Response to Planning application from Hertfordshire County Council (T and CP GDP Order 2015)

District ref: 6/2021/0505/COND
HCC ref: WH/5814/2021
HCC received: 22 February 2021
Area manager: Matthew Armstrong
Case officer: Paul Marshall

H R OWEN MOSQUITO WAY HATFIELD AL10 9WN

Submission of details pursuant to conditions 1 (construction management plan), 2 (surface water drainage) and 7 (details of foundation design of approval) on planning permission 6/2019/1411/MAJ.

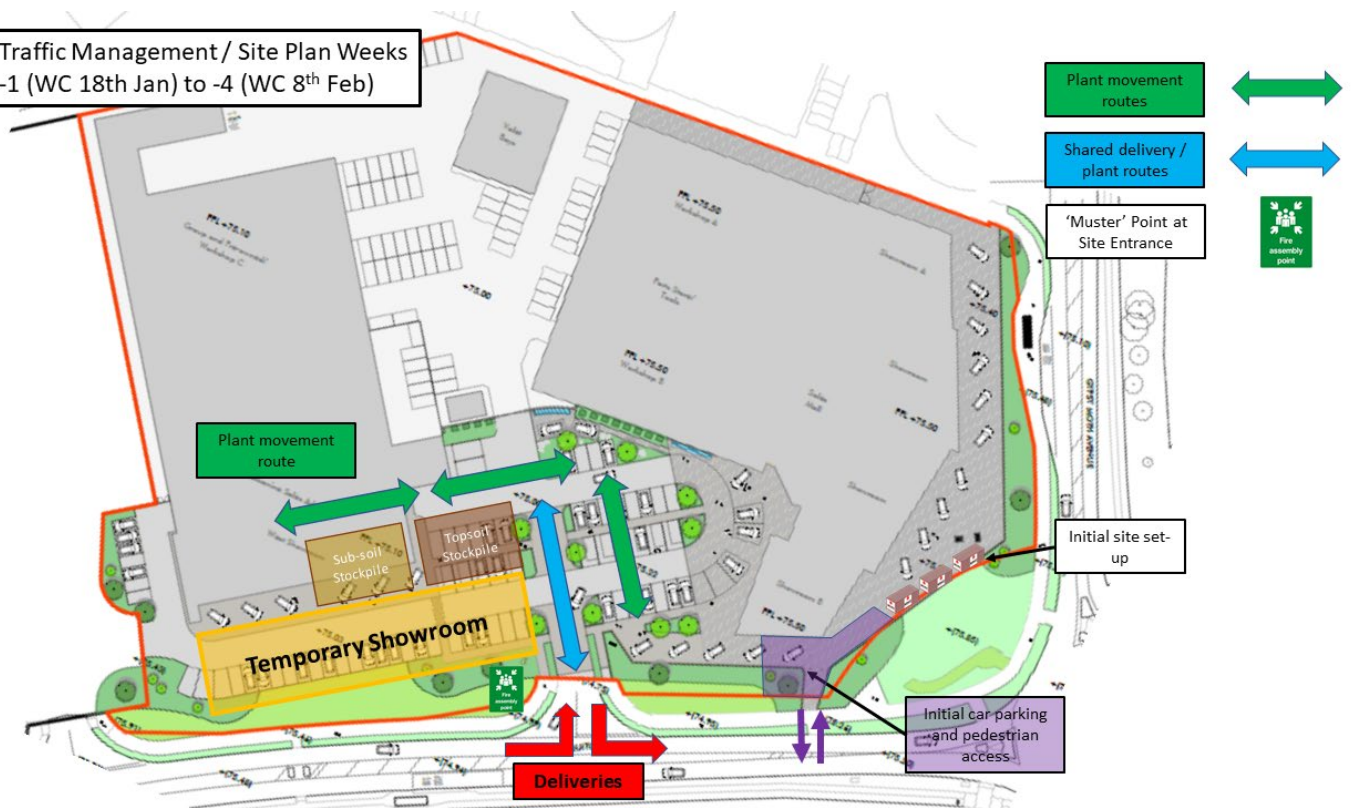
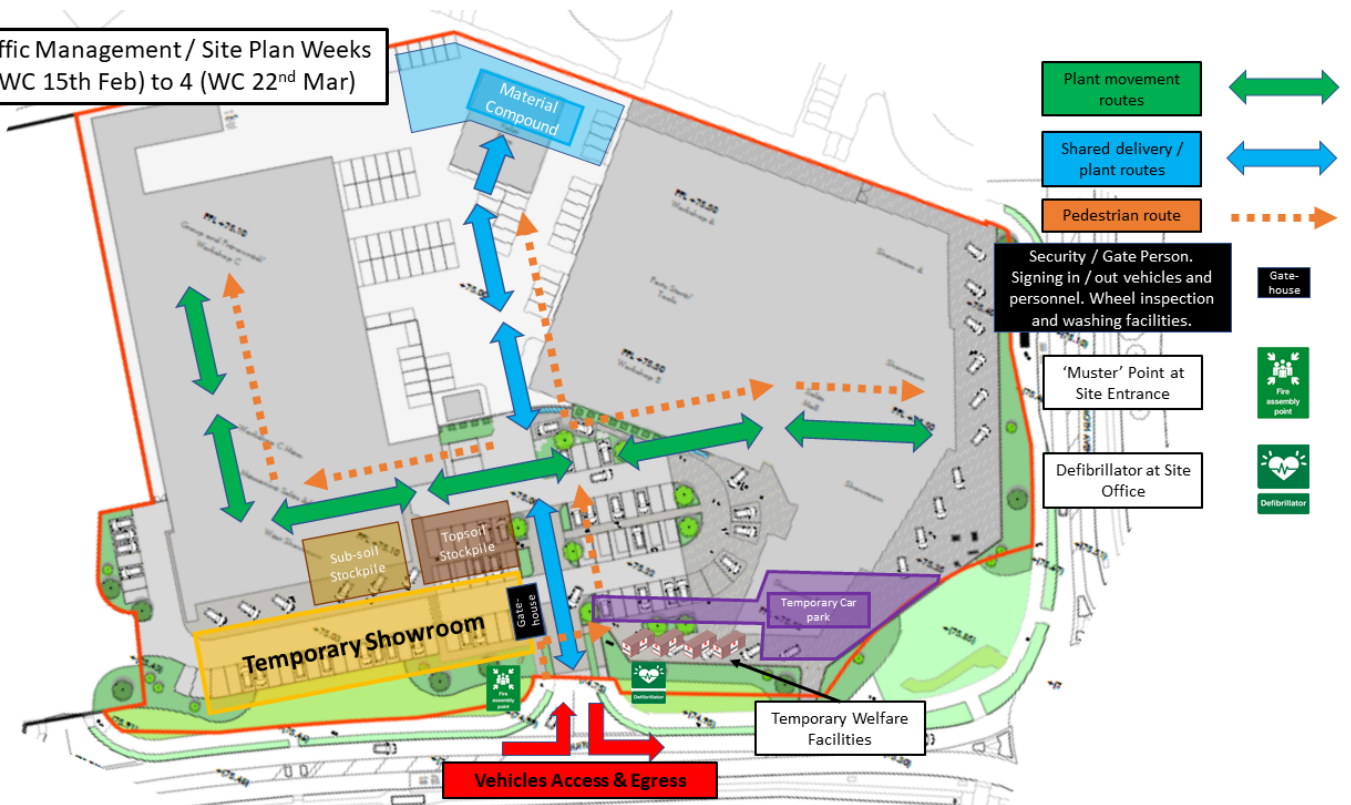
4.51 of the document demonstrates storage, contractor parking, access to pedestrians all of which is accepted by the Highway Authority.
